Arun District Conservation Area Advisory Panel
c/o Civic Centre

21st September 2020

Application No: LU/219/20/L
Site Address: Flintstone Centre East Street Littlehampton BN17 6AW
Description of works: Listed building consent for the erection of new fencing & gates to the rear & sides of the building & removal of wire mesh fencing & gate between the playground & building.

Status: PROPOSED

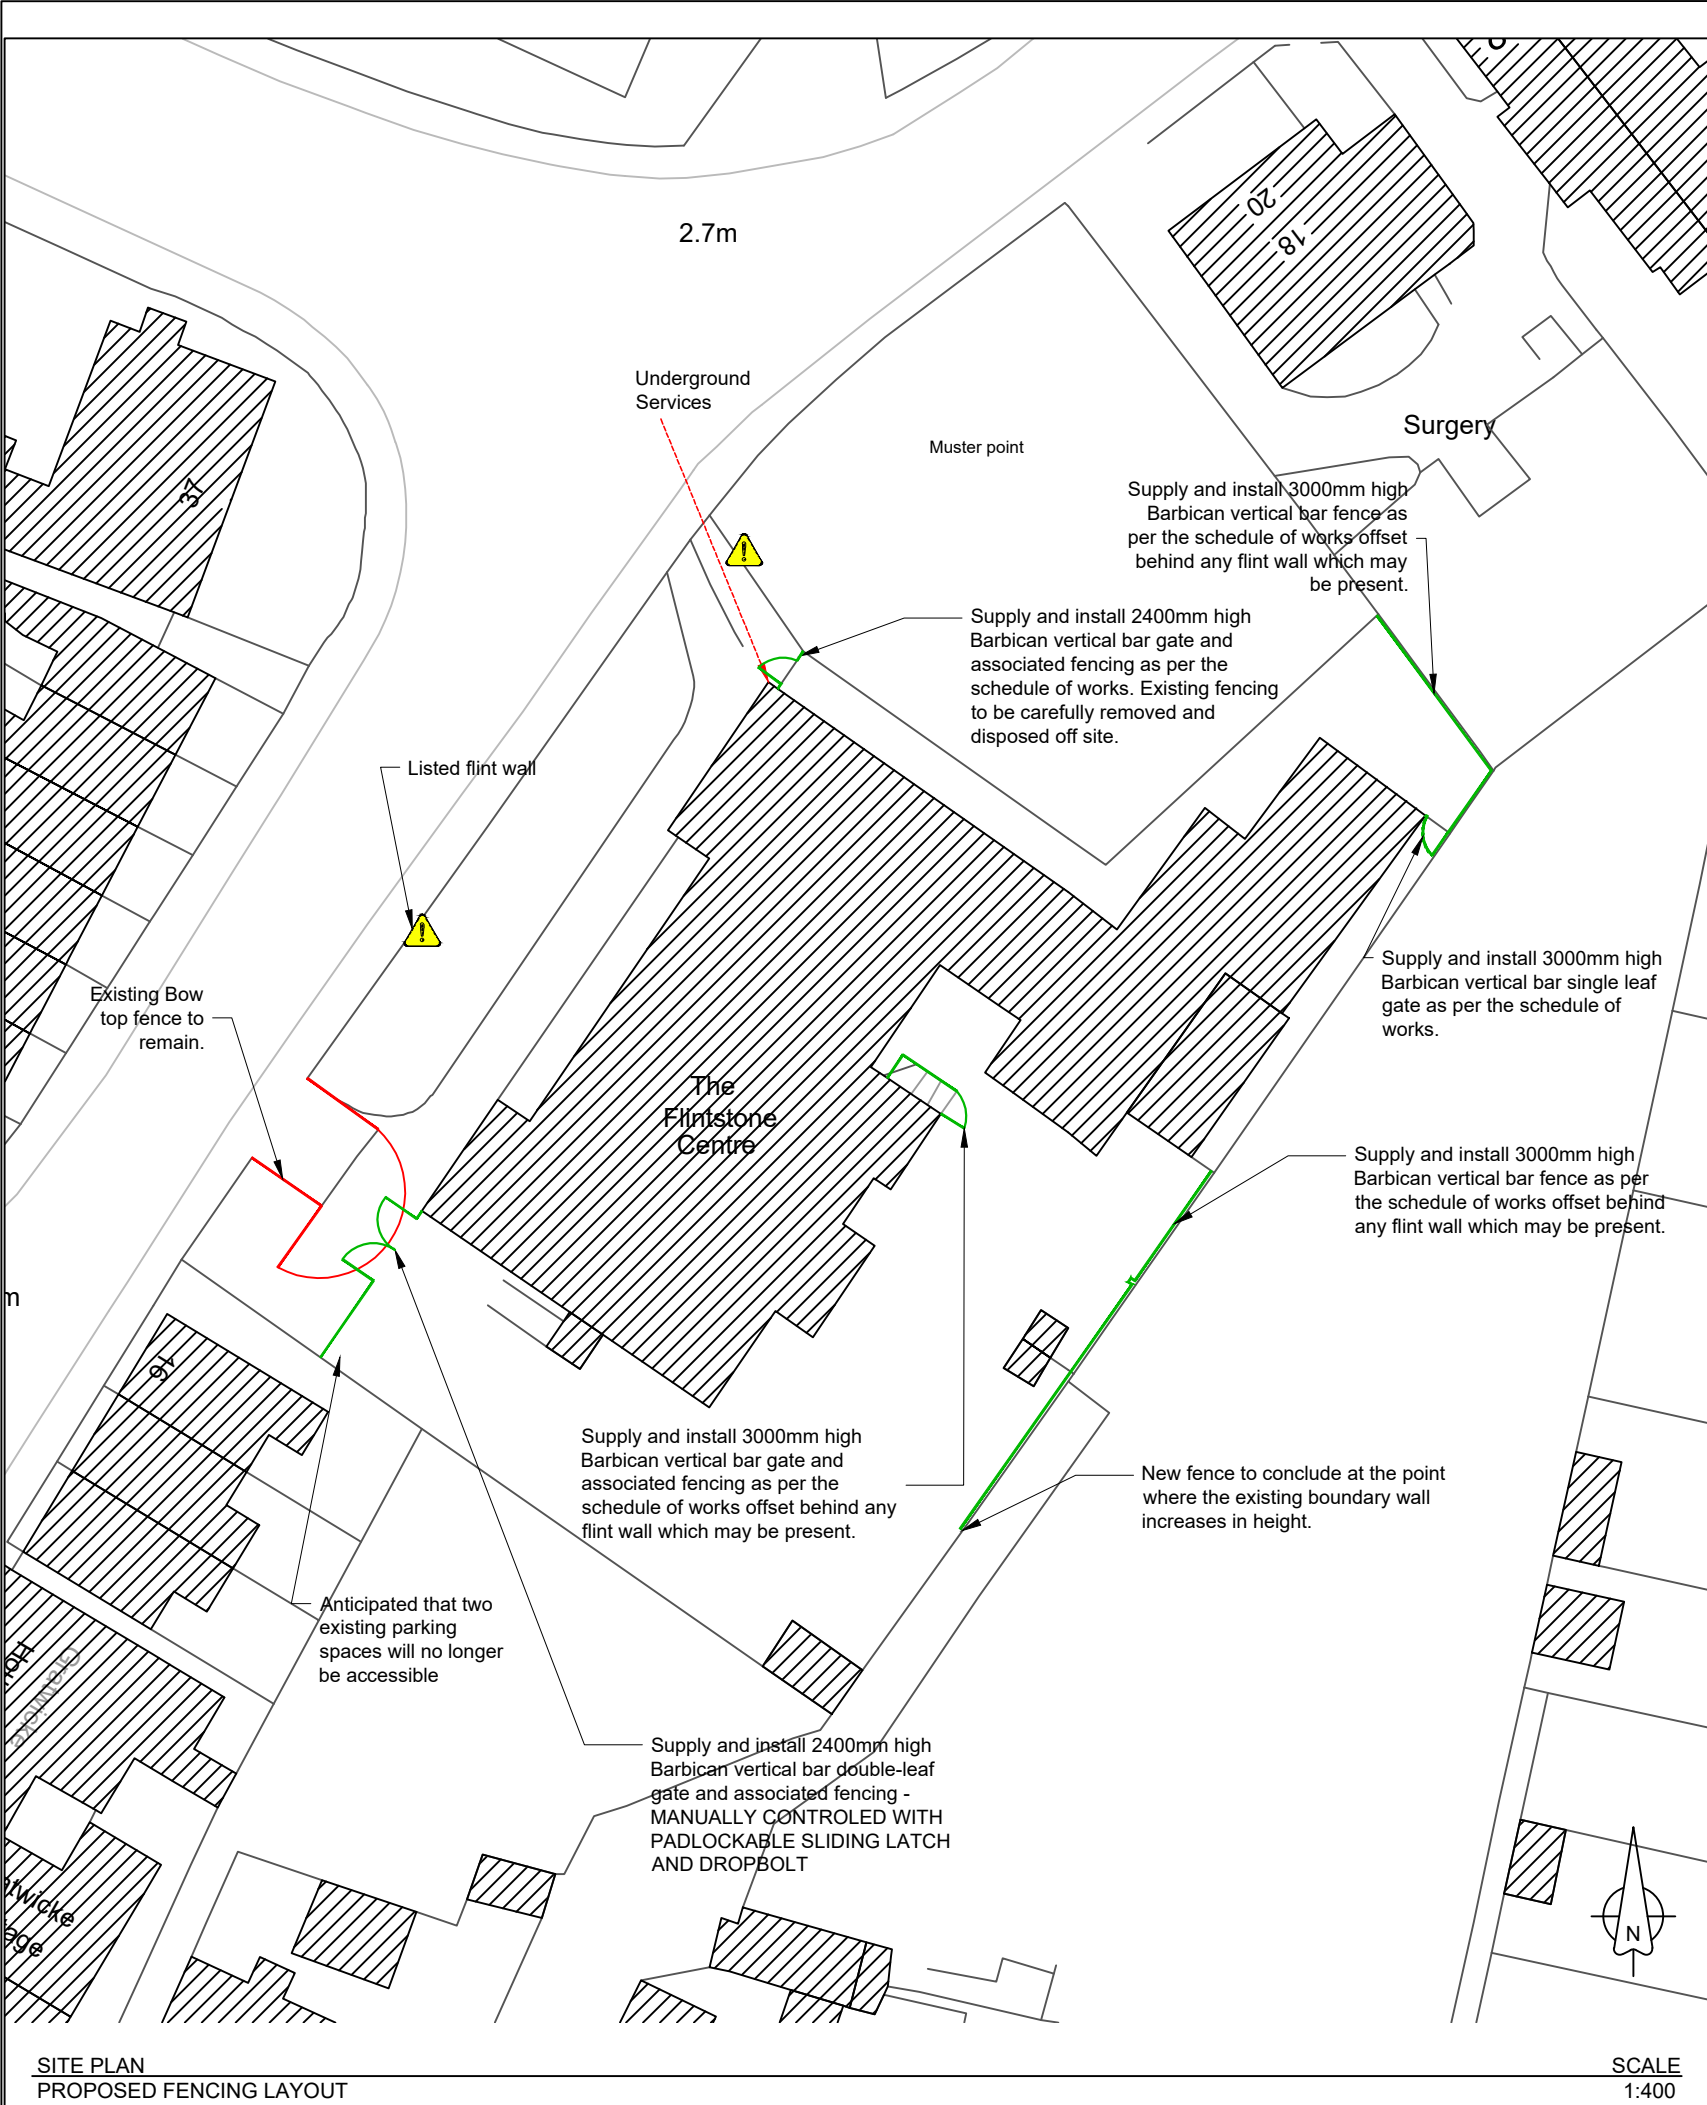
The need for security of the site is fully appreciated. However, the fencing proposed at the front of the site is considered too bland and industrial in appearance. This will detract from the main elevation of the building which has ornate detailing yet is of a modest and almost domestic scale. It will, therefore, also detract from the character and appearance of the conservation area, together with the settings of the listed buildings mentioned.

Any fencing at the southern part of the site needs to be set back from the front elevation of the building, similar to the setback proposed for the new fencing at the northern end, otherwise it will crowd and detract from the important main facade, particularly since the new fencing will be 3 metres in height.

Given the importance of the building to the history and development of Littlehampton, its high heritage significance and contribution to the quality of the conservation area, the Panel suggest that purpose made fencing of a more suitable appearance should be provided. A Victorian pastiche may not be appropriate or desirable but fencing which, for instance, interprets some of the qualities of the building in a modern and innovative way would be.
